PRE-DESIGN CONFERENCE RECAP

SUBJECT: Mountain View ~~Mount~~ Mobilehome Park

REF: DRAINAGE REPORT FOR MOUNTAIN VIEW MOBILE HOME PARK (L9-D2)  
RECEIVED JULY 22, 1985

REF: CONCEPTUAL DRAINAGE PLAN FOR MOUNTAIN VIEW MOBILE HOME PARK  
(L9-D2) RECEIVED OCTOBER 2, 1985

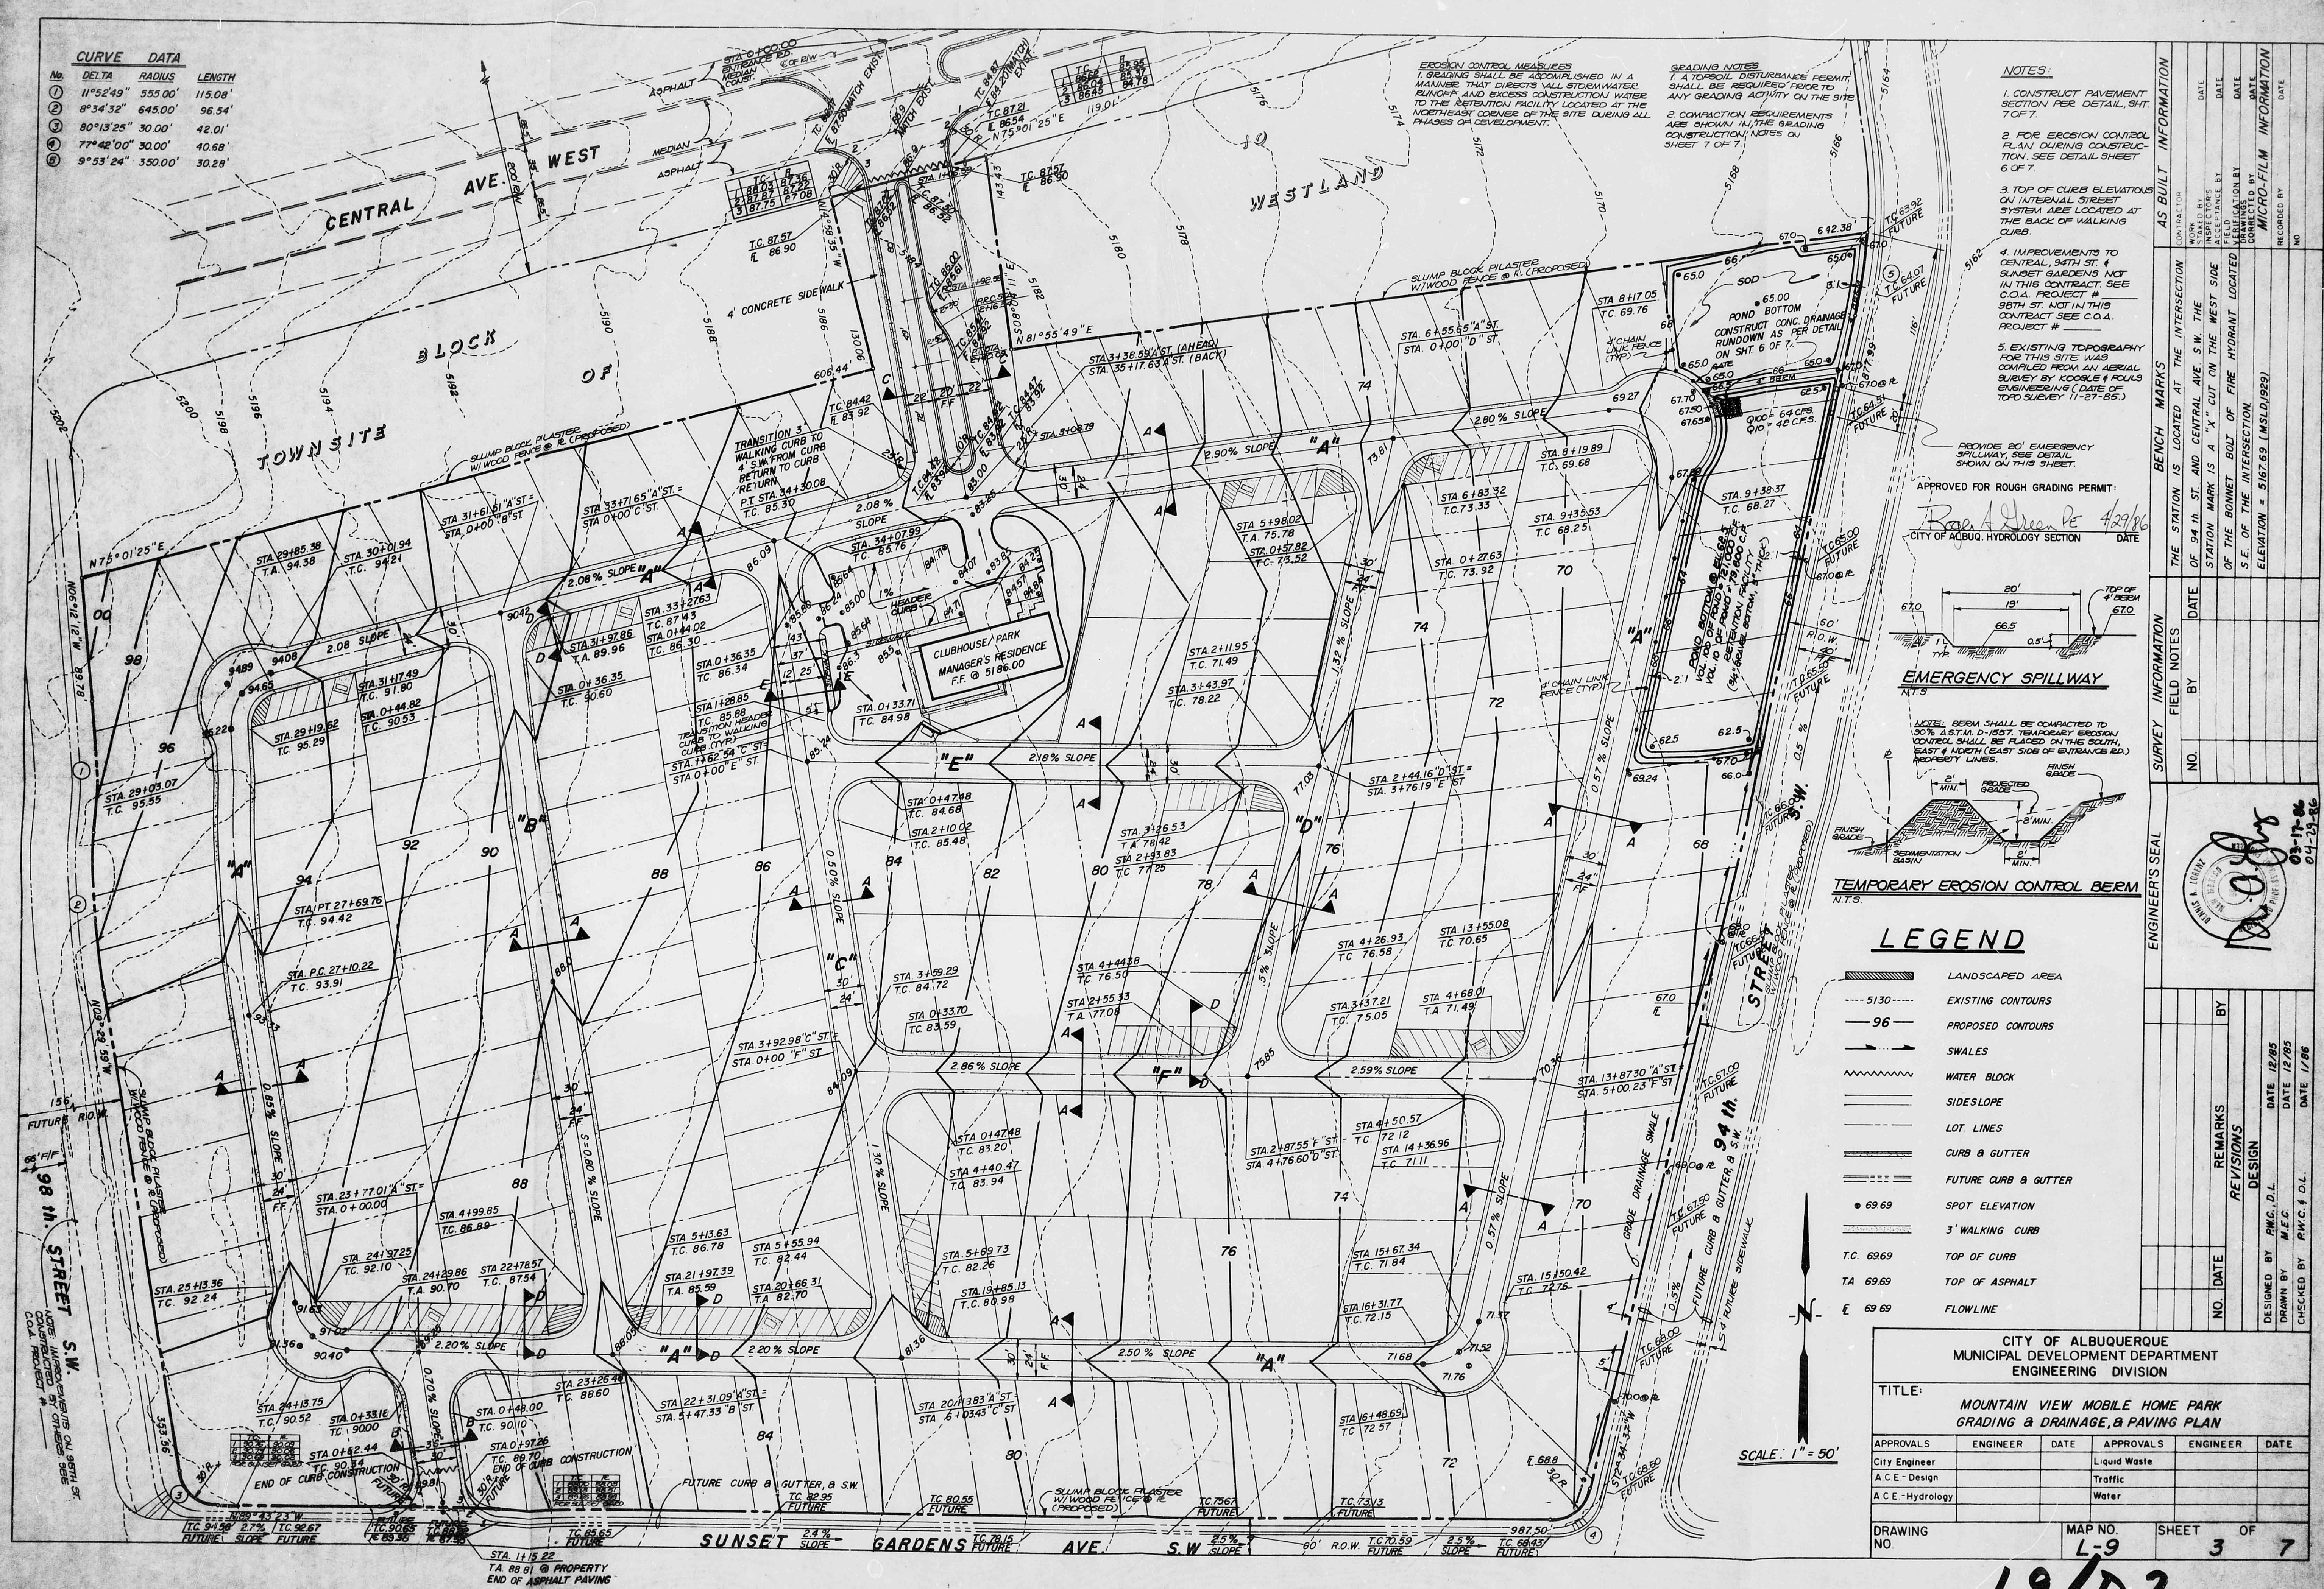
6. Please submit more spot elevations to indicate how the lots will drain.
7. Need section for the 10' private drainage easement swale.
8. Please show top of curb and flow line elevations for the proposed streets.

6. The conceptual plan has sufficient information; i.e. spots, match existing, flow directional arrows.
7. See section attached.
8. Superfluous information for conceptual drainage plan.

REMARKS *Carlos - Thanks for "holding" the file out. Here is the revised plan with: (1) preliminary street grades on S. Gardens/94th St. (2) temporary pond for developed flows on S. Gardens (barricaded) (3) Revised entrance off S. Gardens (4) Project address (5) P.E. Stamp, date, signature as requested on original - P.S. info. Sheet completed w/in Drainage Report*
